All About Outdoor Storage, PPR-16-37

Please accept the following comments from El Paso County Public Health regarding the project referenced above:

Mike McCarthy
El Paso County Public Health
Environmental Health Division
719-575-8602
mikemccarthy@elpasoco.com
05Dec2020

PROFILE - POND AND OUTLET
SCALE: H1"=50'
V1"=5'

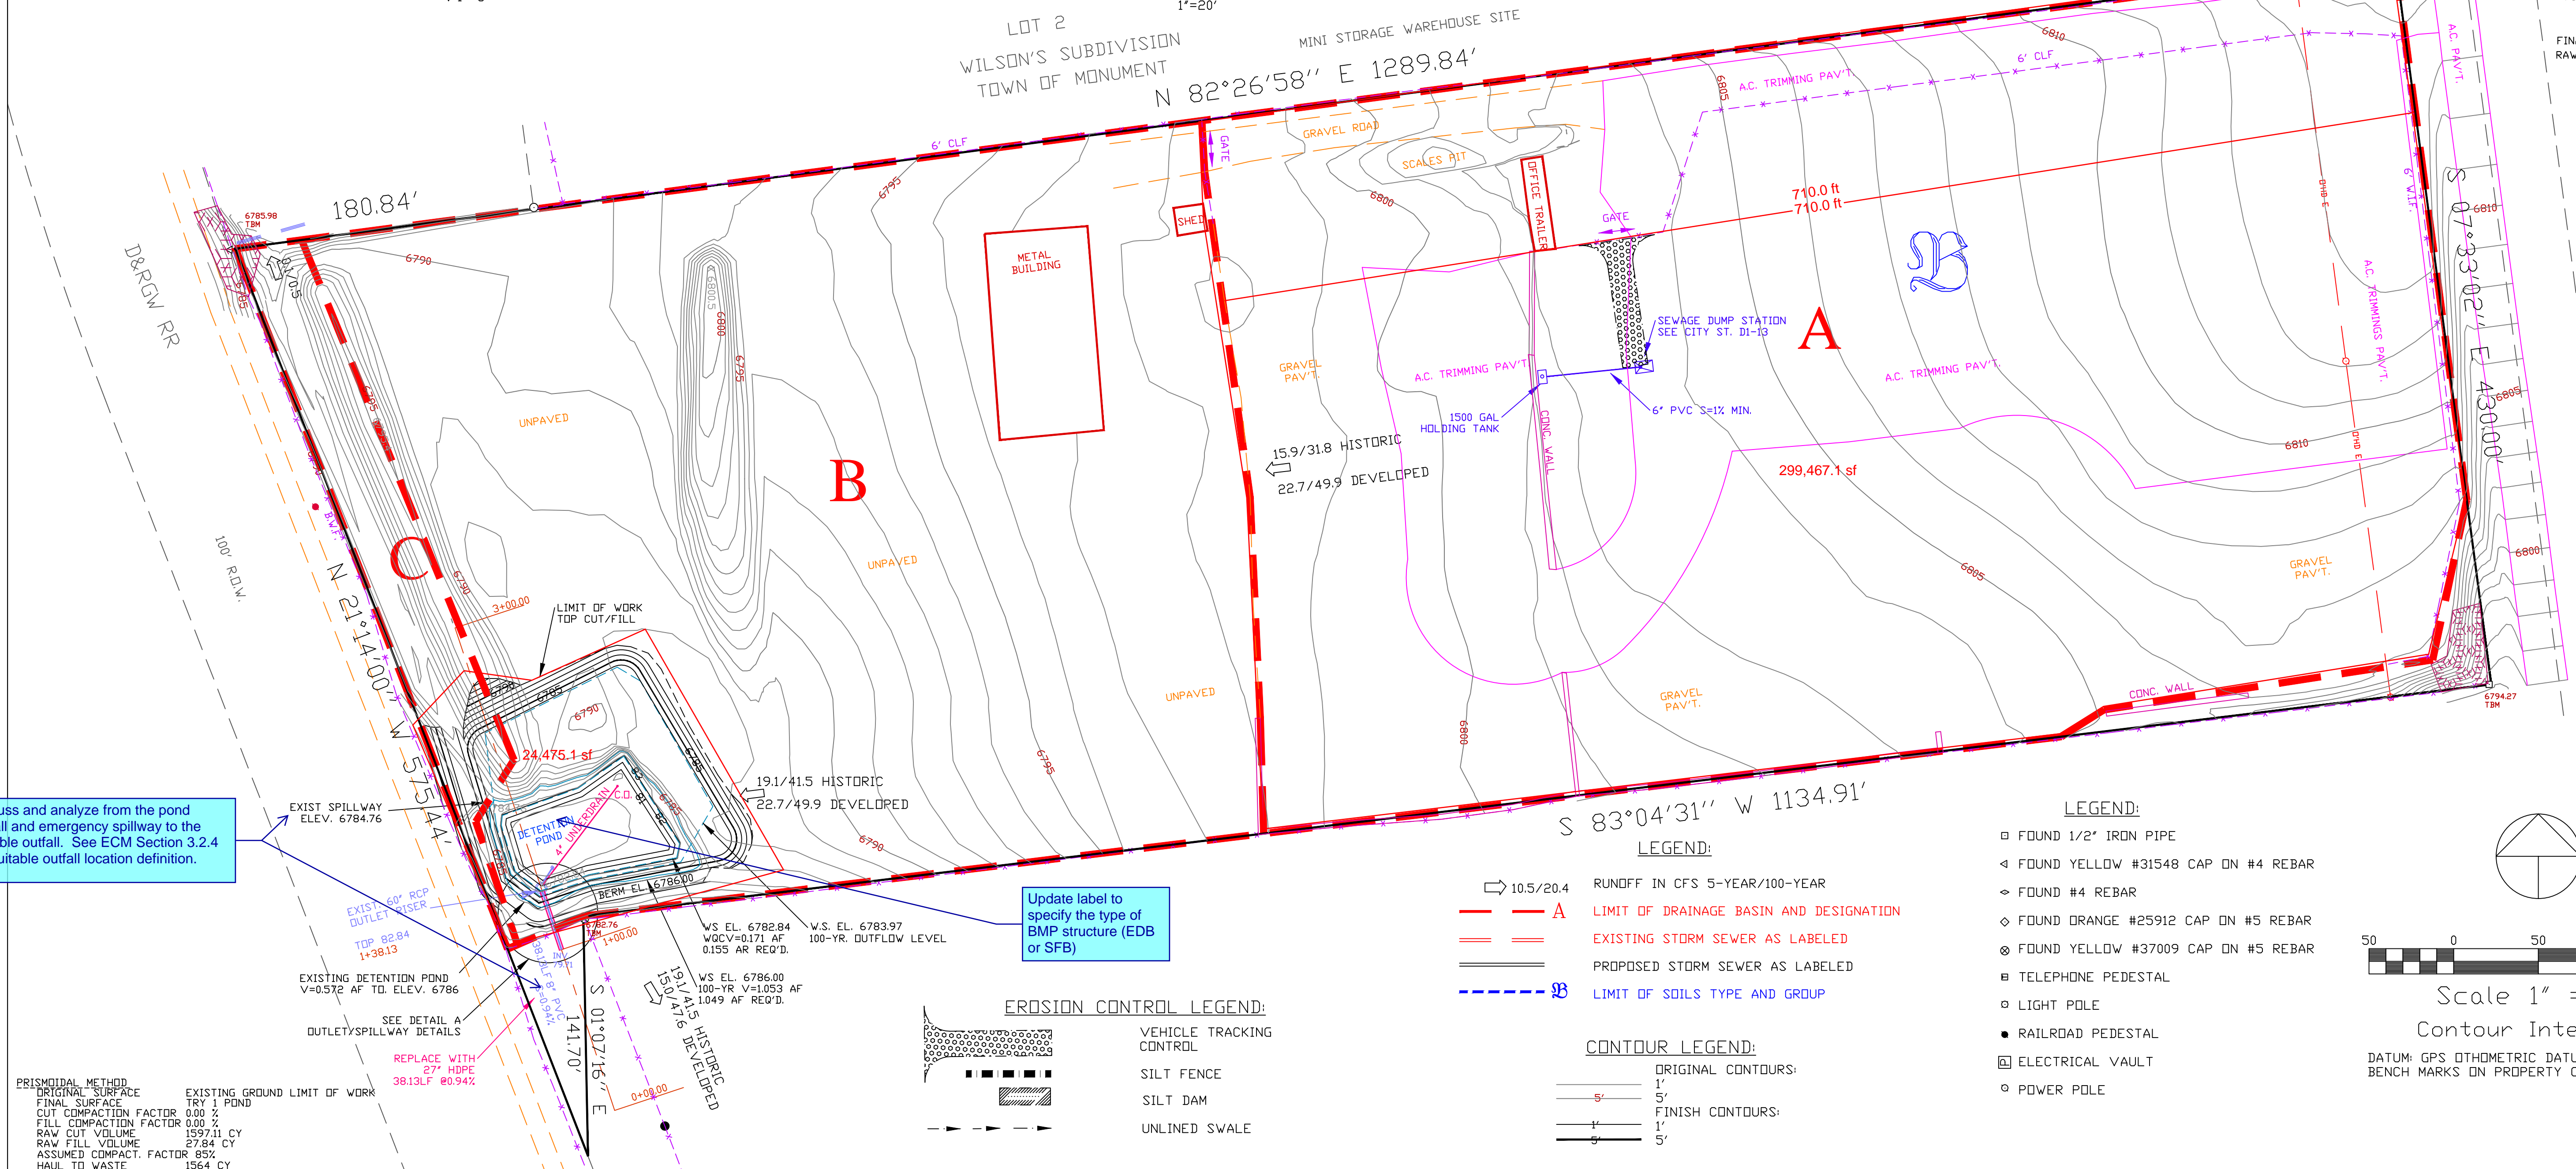
- The water quality detention basin must have mosquito control responsibilities included in the maintenance plan to help control mosquito breeding habitat and to minimize the potential for West Nile Virus.
